Lewes District Council

Our Ref: SDNP/23/01244/PRE
Contact Officer: Chris Wright
Tel. No.: 01273 415461

PRE-APPLICATION ADVICE

Site Address: 26A Station Street, Lewes, East Sussex, BN7 2DB

Drawing No: 157_APD.PL.02

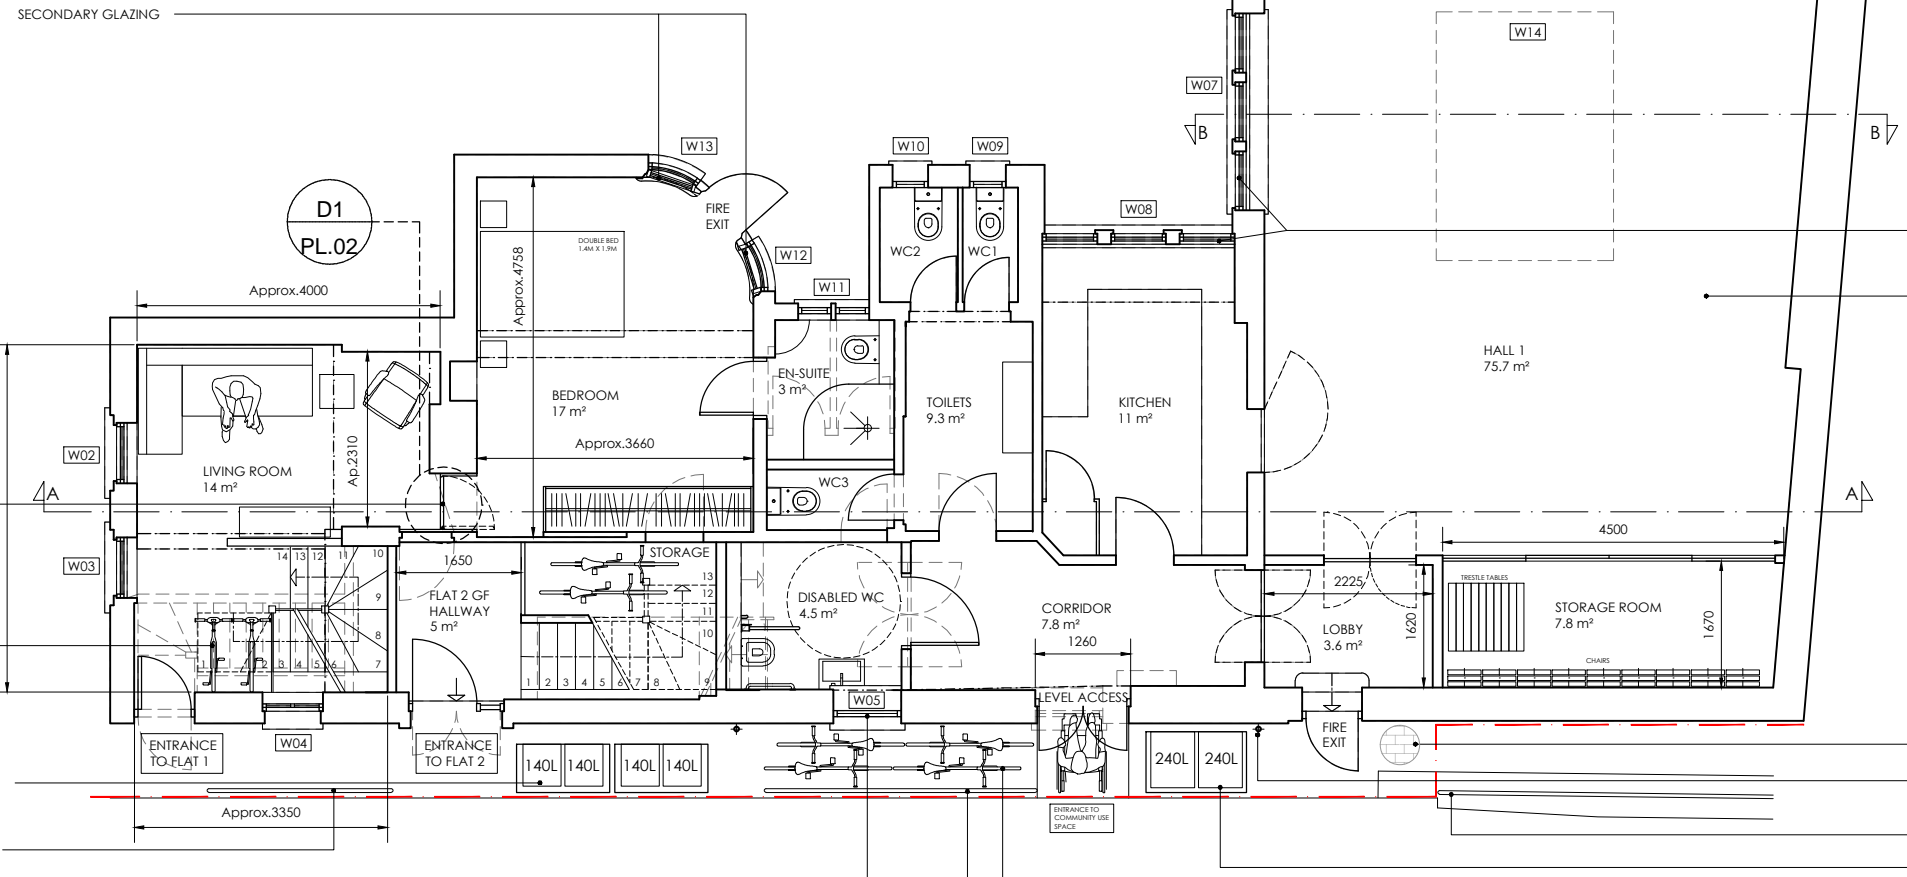
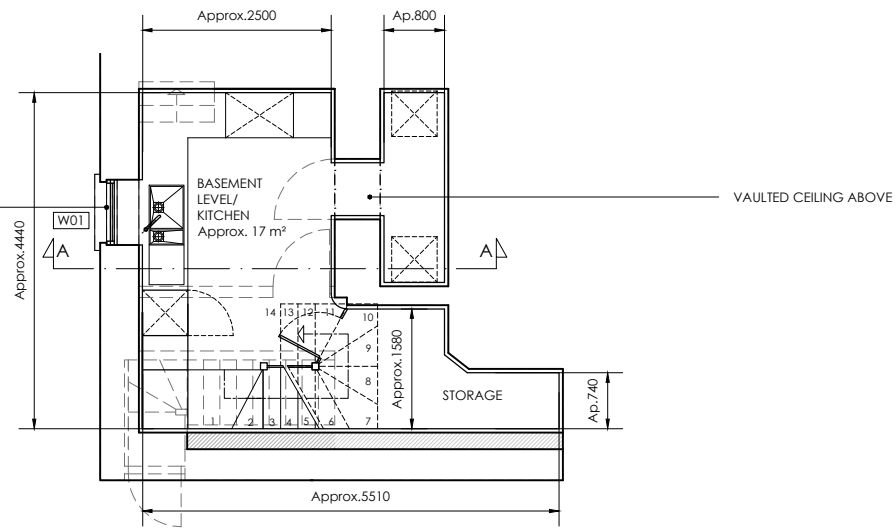
- o Creation of internal partitions to form lobby and storage room at the back of the hall, which will align with the existing passageway along the side of the building is likely to be acceptable because it is reversible intervention and would not have an adverse impact on the historic plan form of the listed building. Similarly this would apply to the formation of a disabled W.C. in the passageway.

- o The new entrance may involve the loss of some original historic fabric to the listed building. This should be sensitively designed but it is noted that this would help to preserve the community use on the ground floor.

- o With respect to the proposed kitchen this will need to be carefully considered as to the impact on original features internally.
- o Altering the windows / doors to this room is unlikely to be acceptable due to loss of historic fabric and effect on intrinsic and architectural character of the listed building.

- o If obscure glazing is required, a removal film should be applied to the windows / doors instead, as this is removable and would not involve damage or loss of original fabric.

- o Works to the W.C. facilities, or which there appear to be five, should be acceptable if these are modern partitions. Generally speaking creating new doorways and openings through original walls would not be acceptable and would result in the loss of historic fabric.

- o Retaining the door to the hall as an emergency escape only would be acceptable and its use in emergencies only would be a private agreement between the hall user and the neighbouring house. The neighbouring house does not appear to be connected internally with the proposal site and both sites have overlooked the same outdoor amenity space for some time.

Proposed First Floor Plan - Flat 2
 SCALE 1:100 @ A3

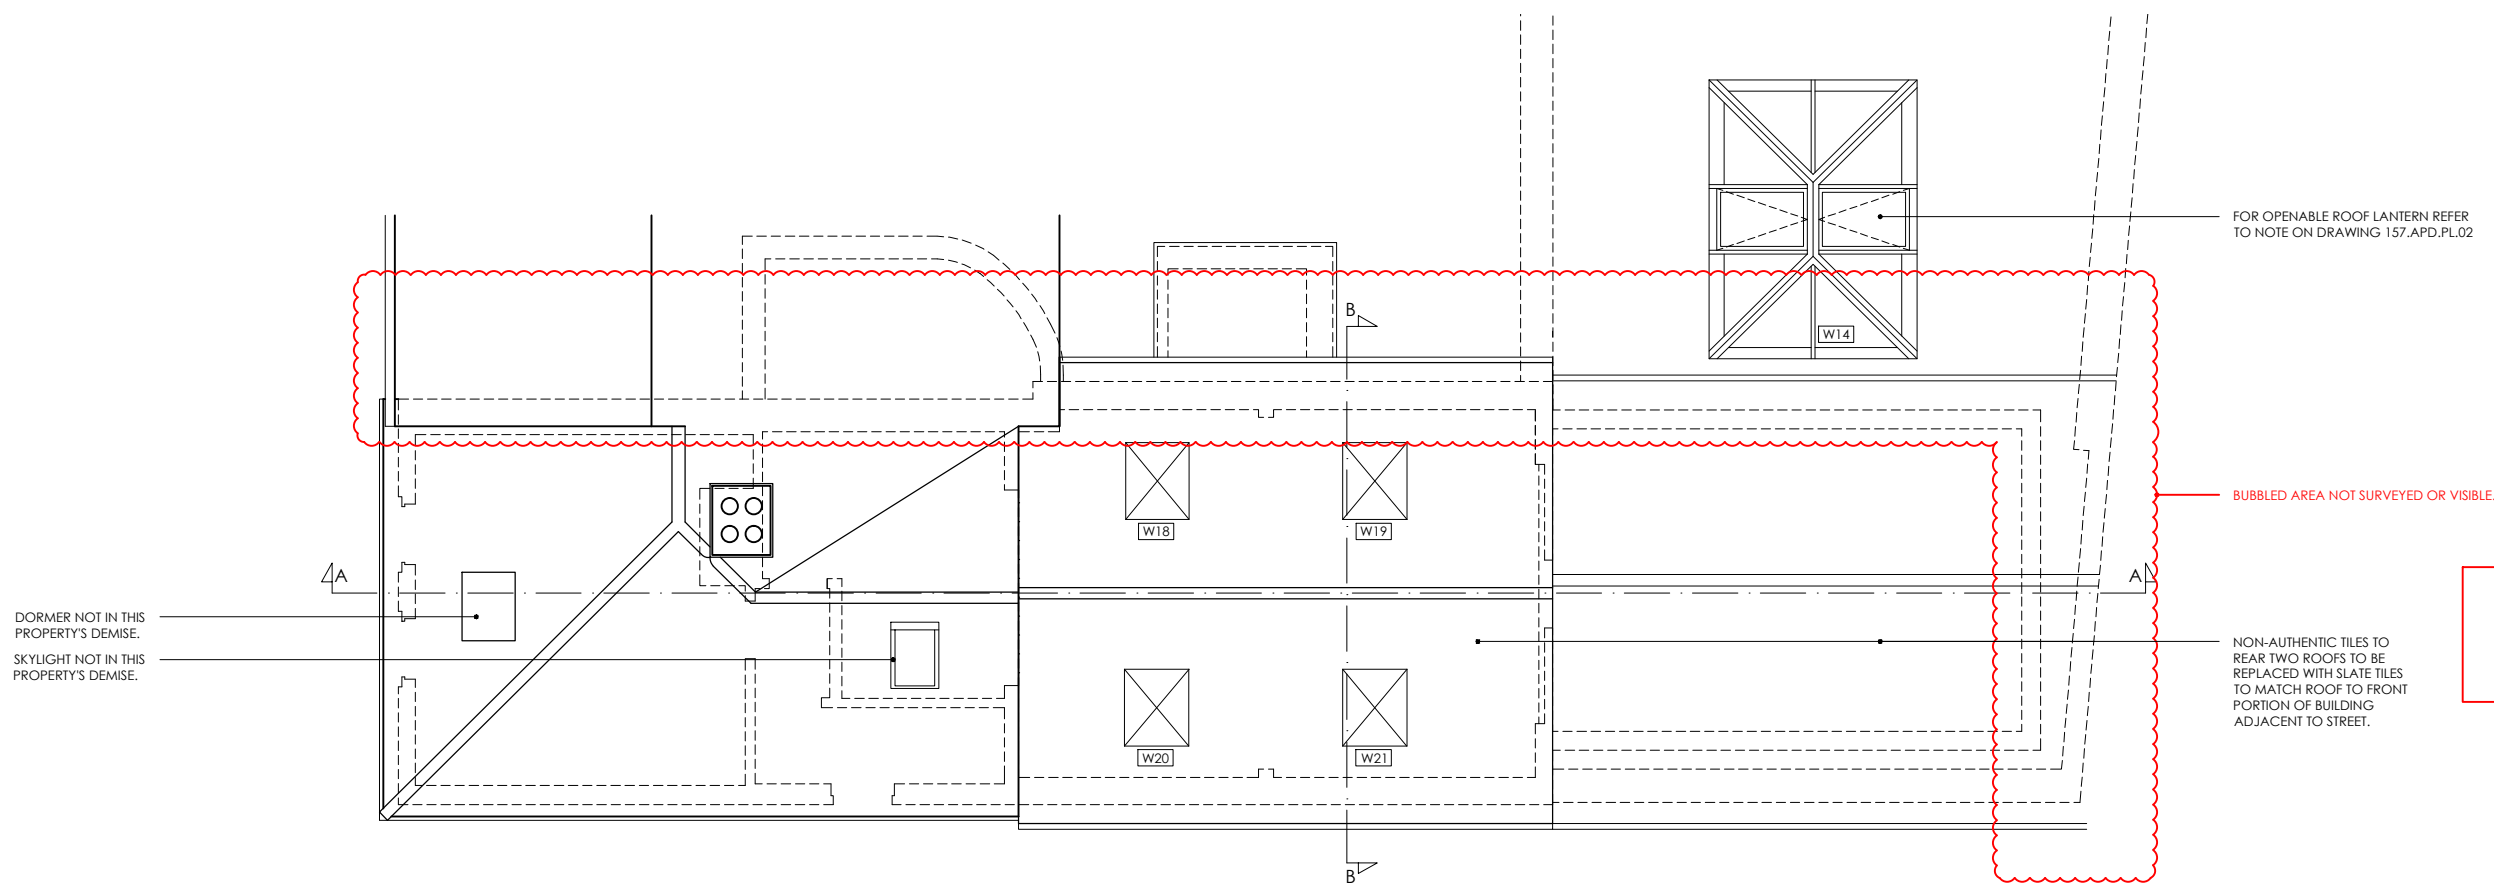
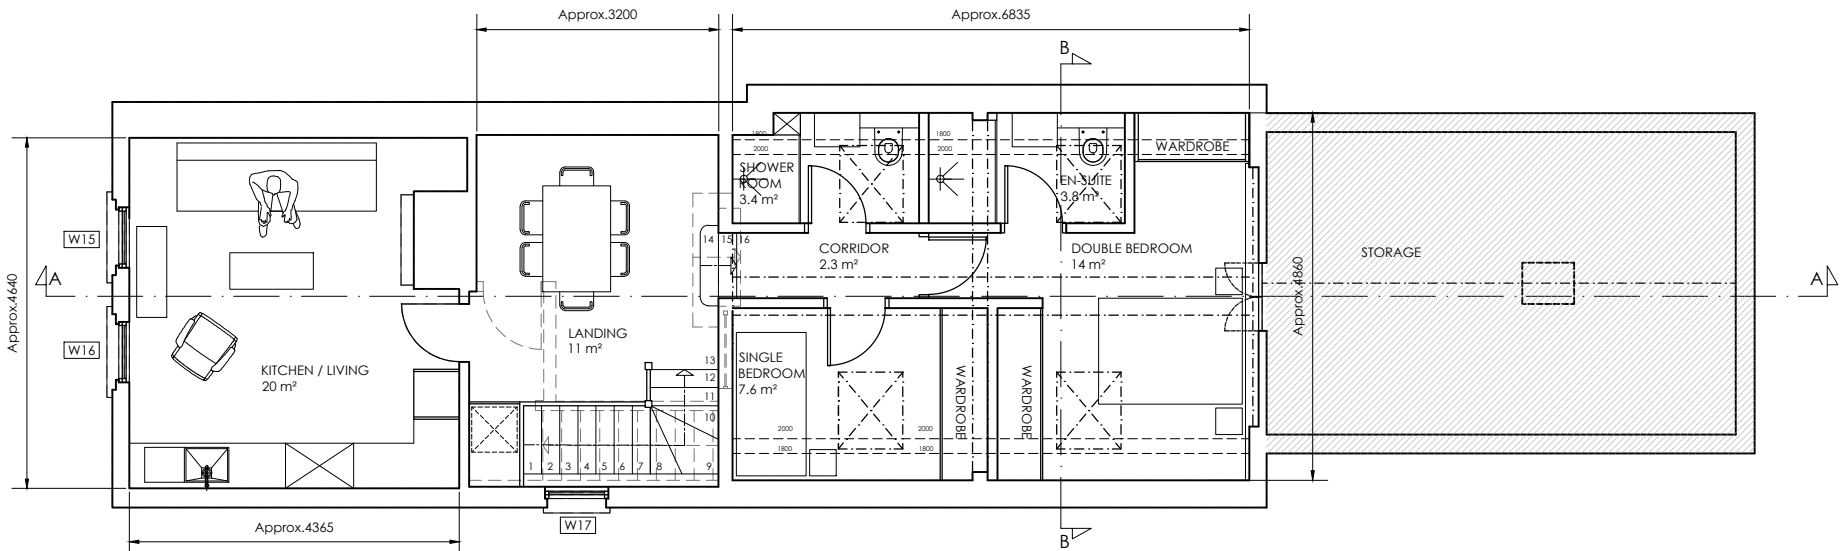
- o Removal of glass panel and re-opening an old doorway at first floor level is likely to be acceptable.
- o The new partitions to form W.C./shower and bedroom at the back do not appear to follow the historic plan form of the listed building.
